2 February 2017

Our Reference: SYD16/00656/03 (A15938753)
DP&E Ref: SSD 7664

**PROPOSED HORSLEY DRIVE BUSINESS PARK – STAGE 2
COWPASTURE ROAD, WETHERILL PARK**

Project:
0300
Horsley Drive Business Park Stage 2
Drawing Title:
Site Access 1
Articulated Vehicle

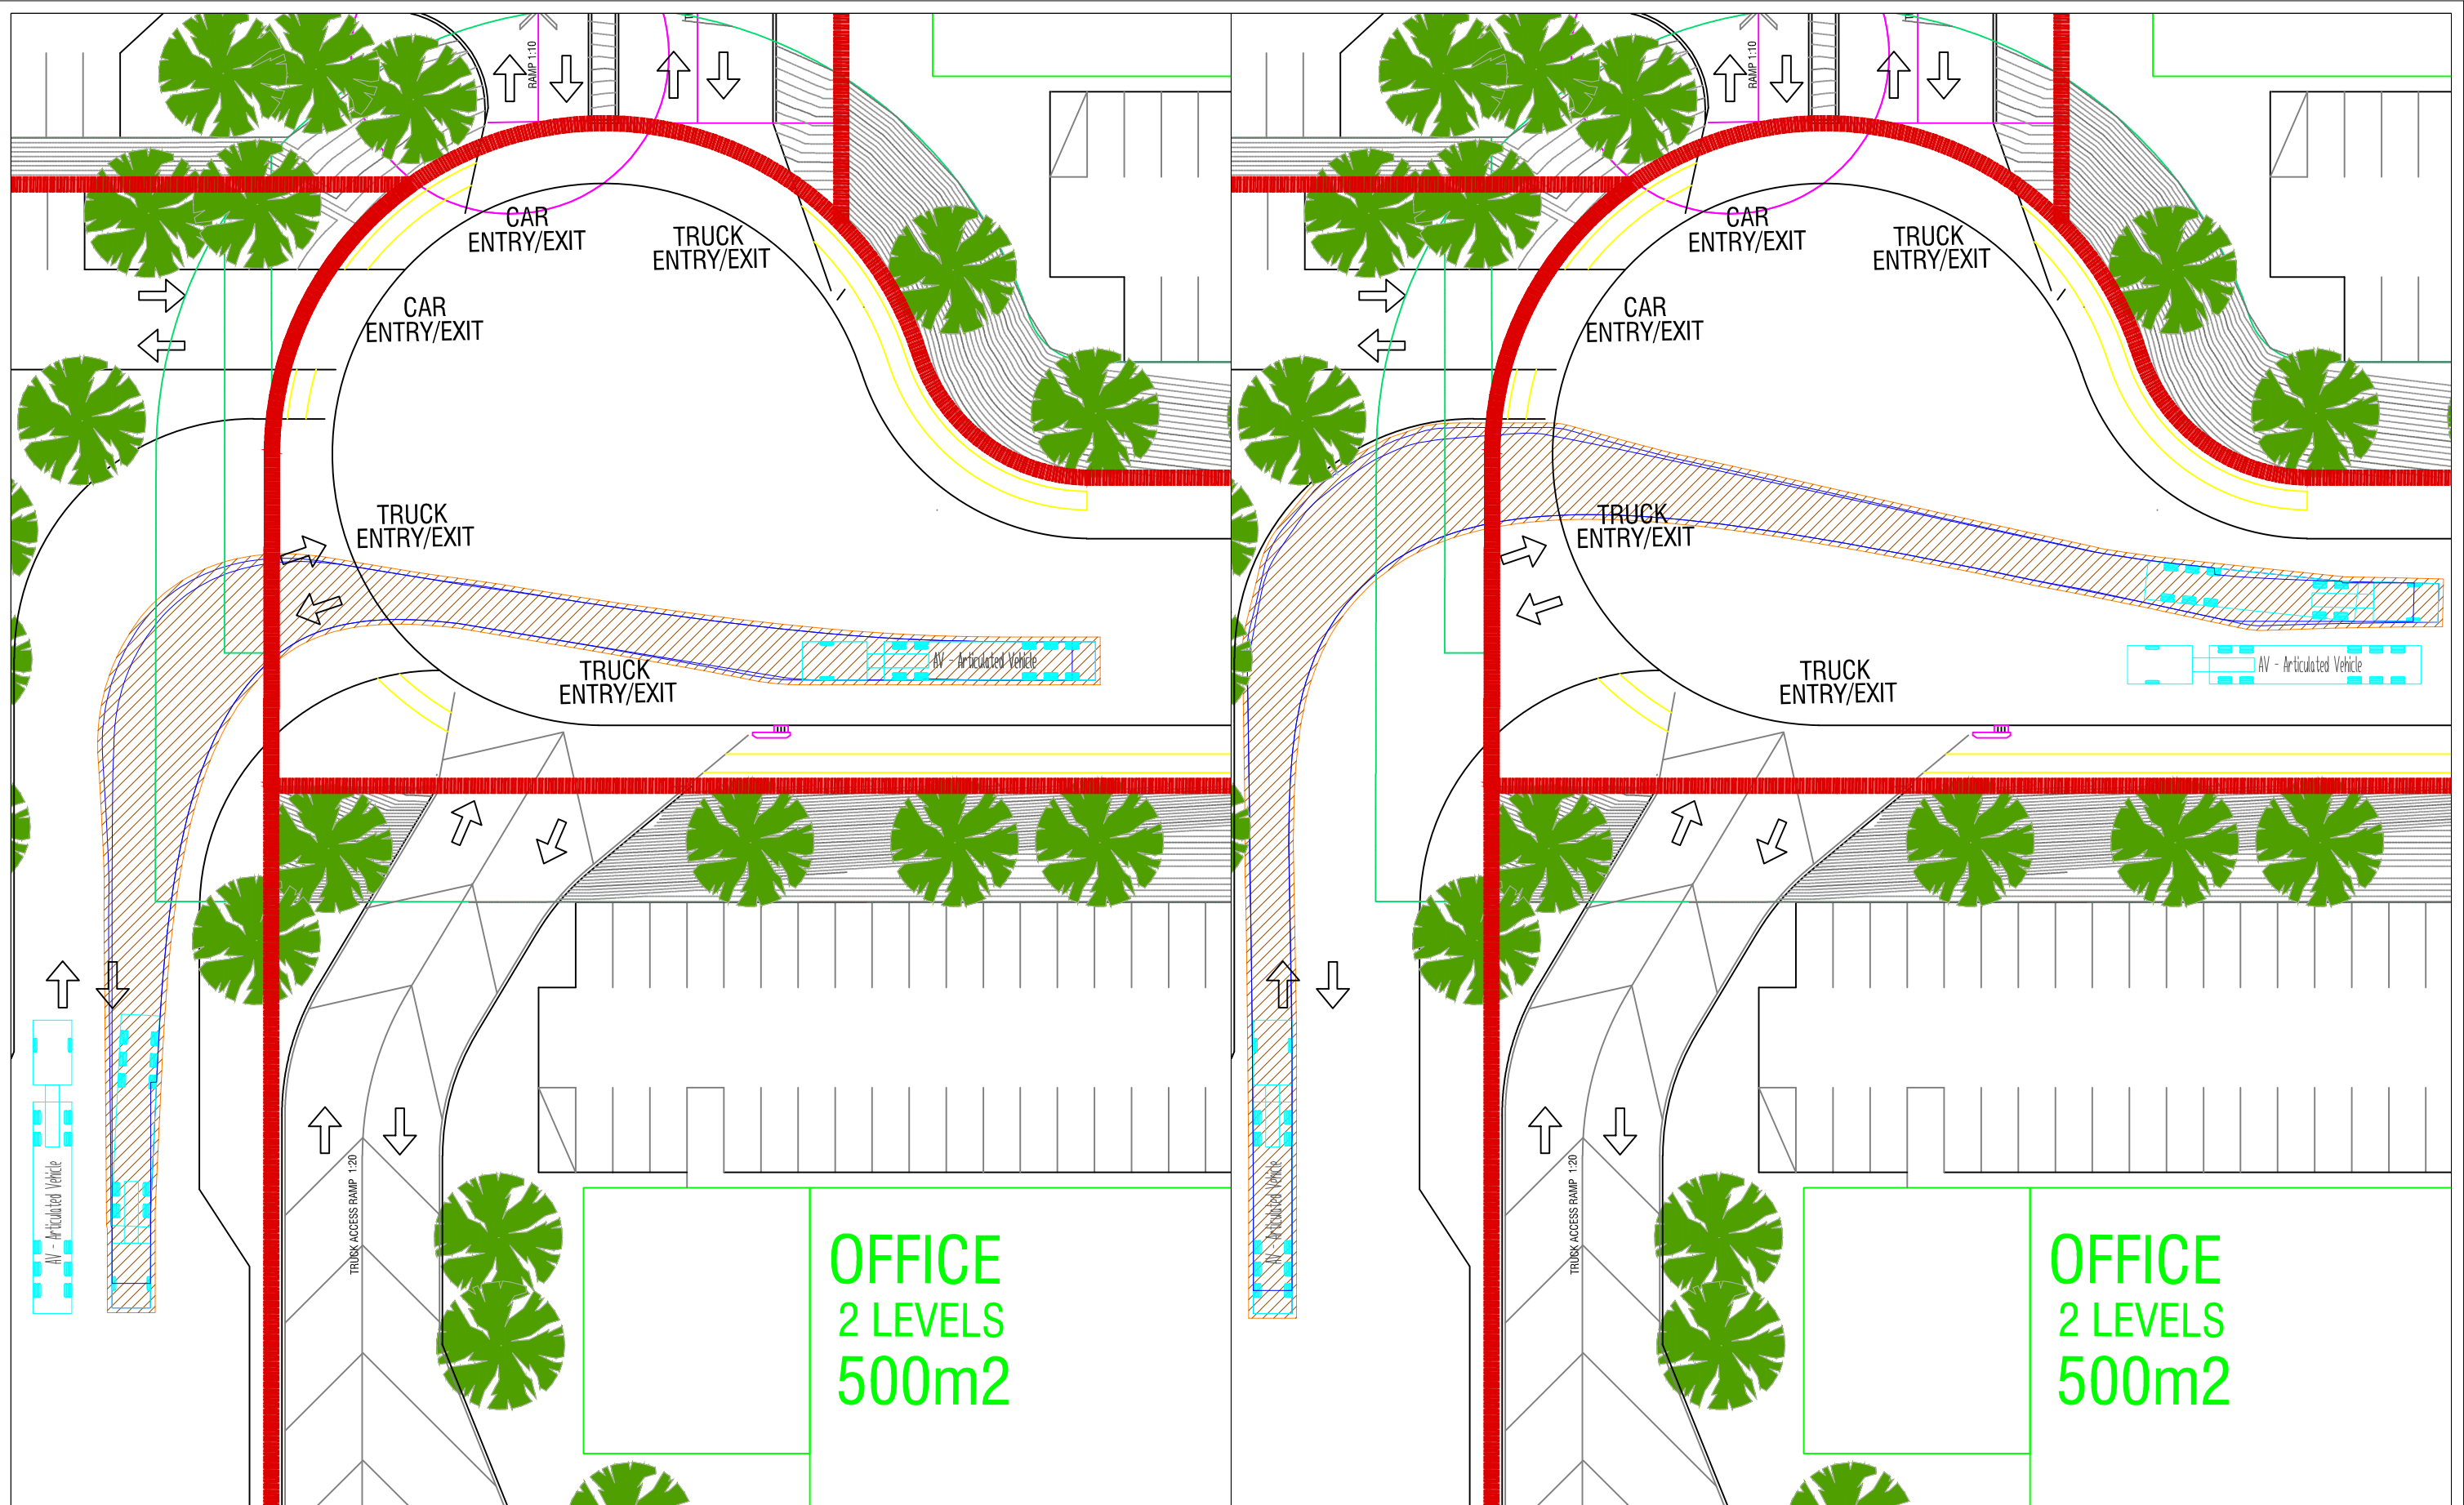
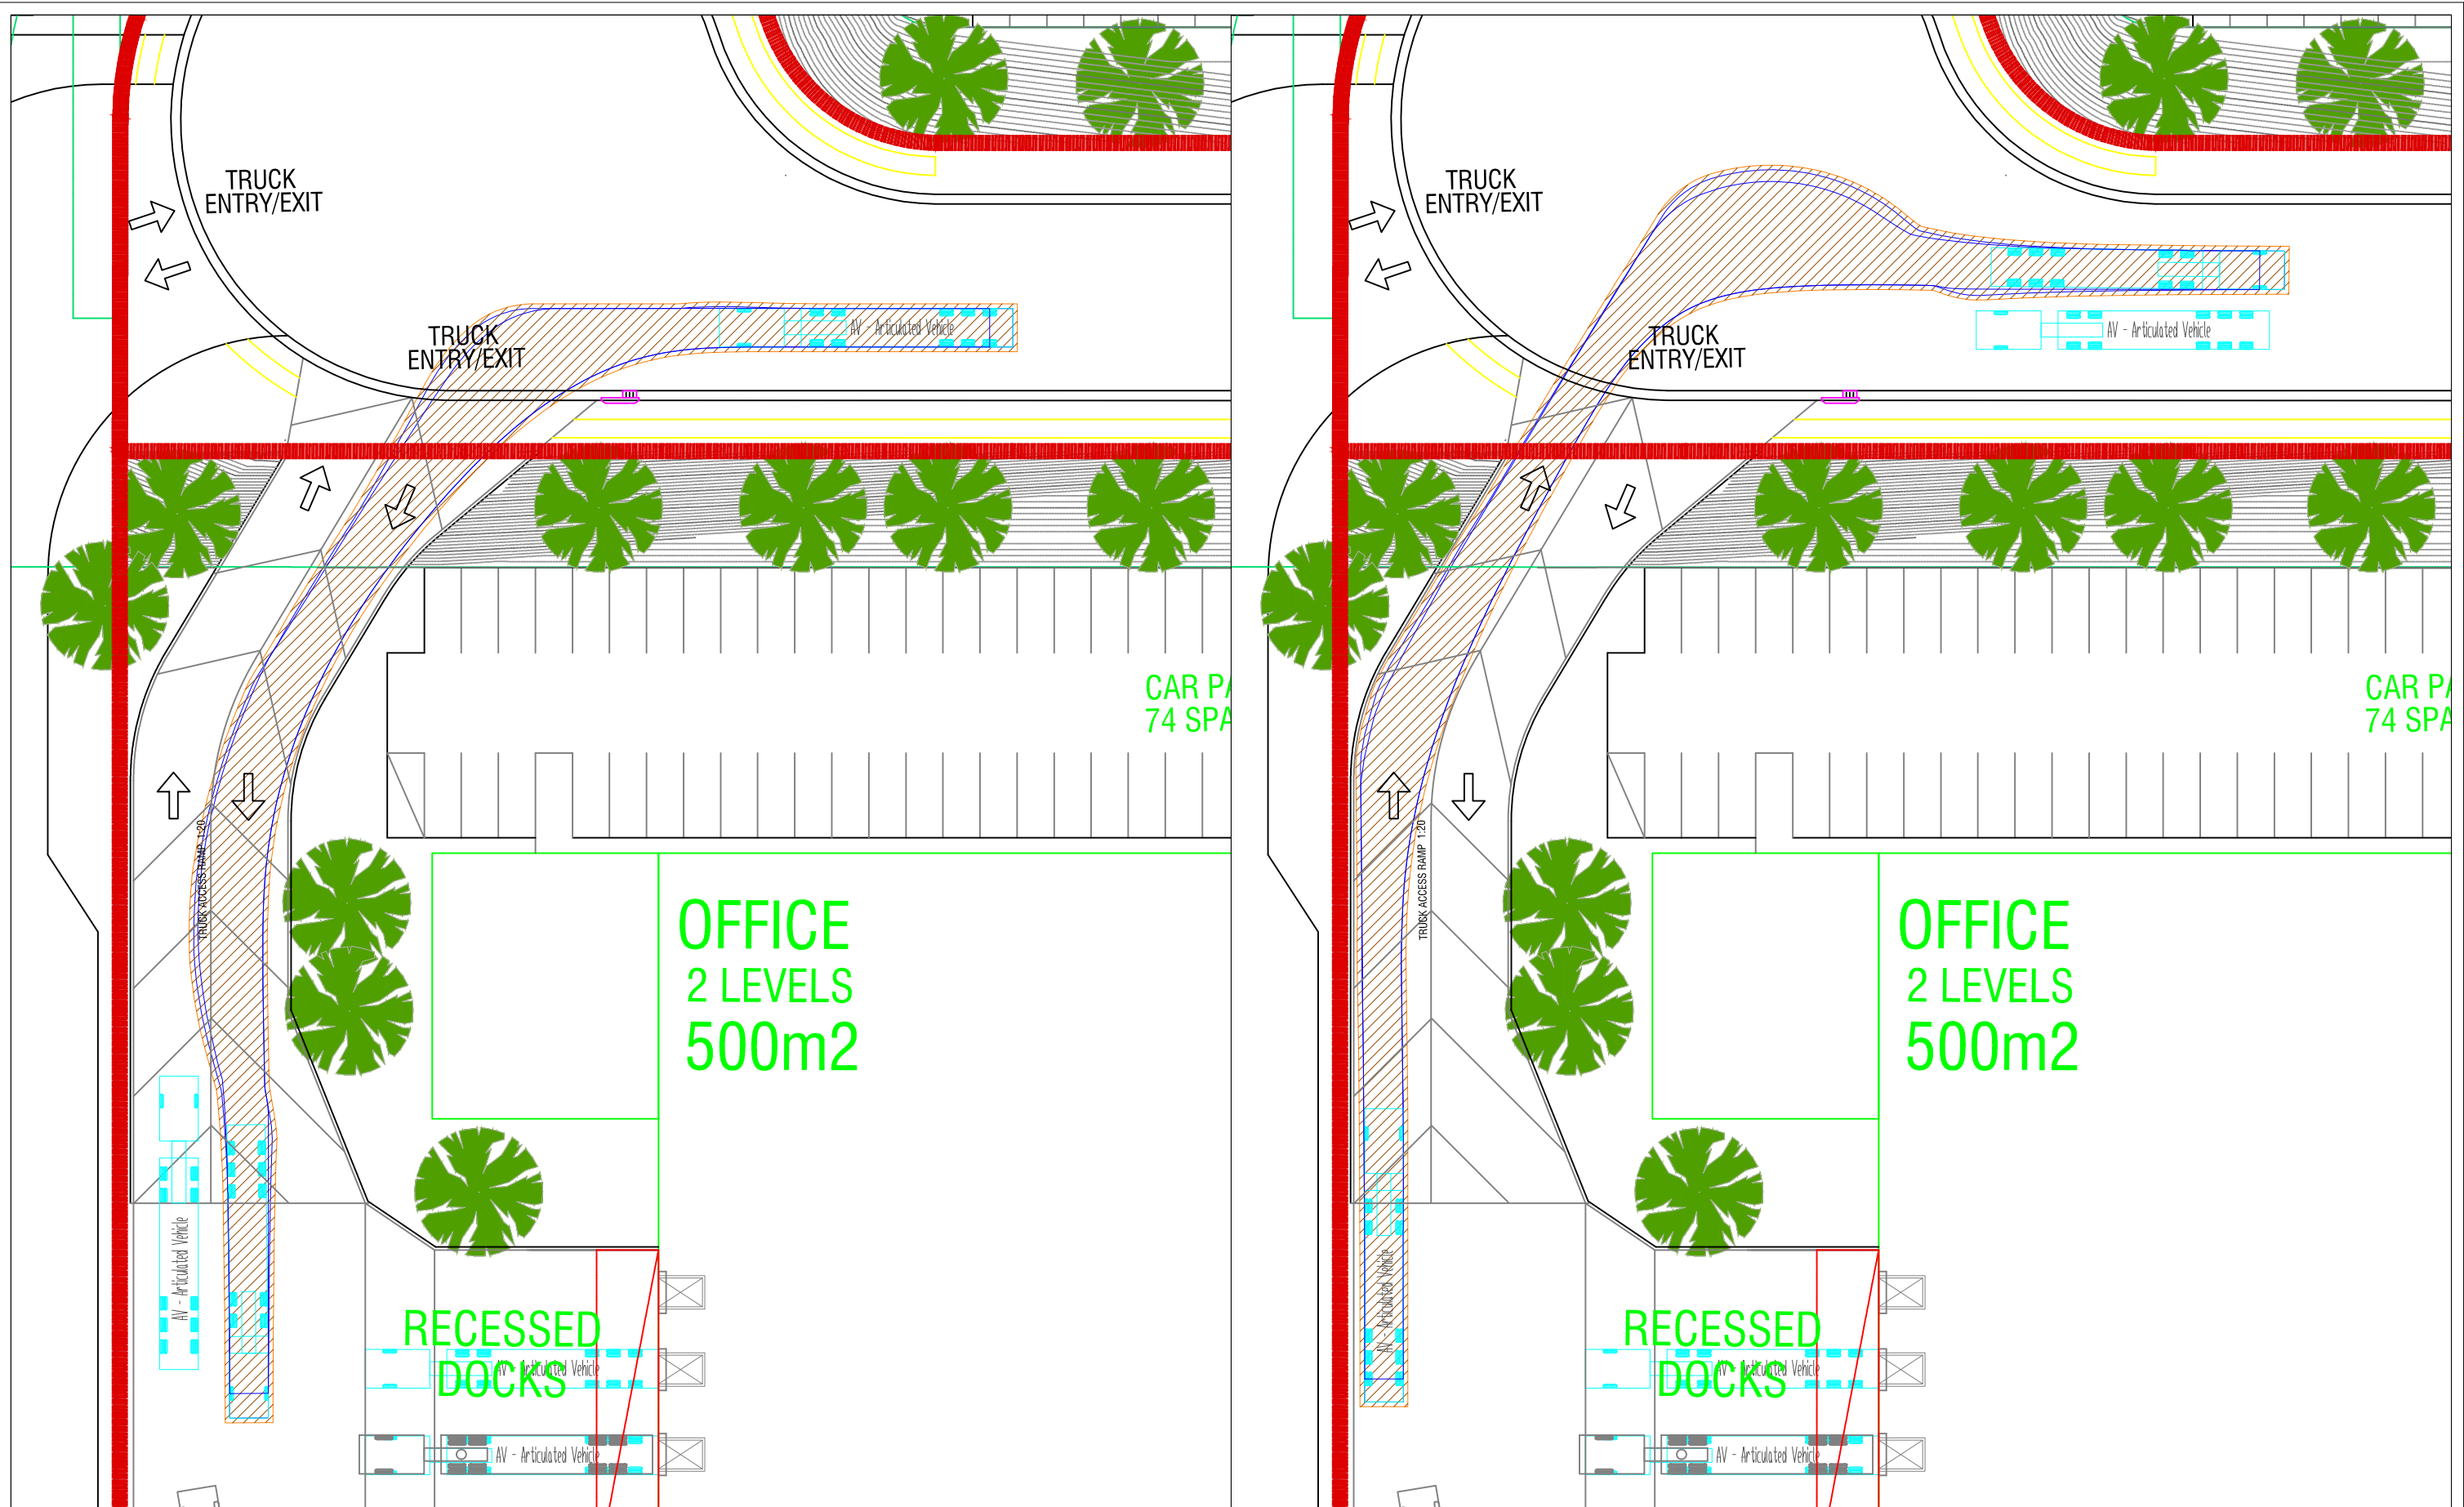
10. The proposed combined vehicle ingress/egress to the proposed Lot 4 is located in close proximity to the proposed Access Road and Cowpasture Road. The truck turning path shows that there is no sufficient space provided for two trucks to pass each other safely at the same time. Concern is raised when a truck is exiting from the combined driveway for Lot 4, another truck would be restricted to enter the site from Cowpasture Road. This potentially results in the truck to be required to reverse back onto Cowpasture Road which is a regional road causing safety issues. The location of the combined vehicle crossing to Lot 4 should be located away

from the Cowpasture Road and sufficient clearance should be provided between the largest vehicles entering and exiting safely.
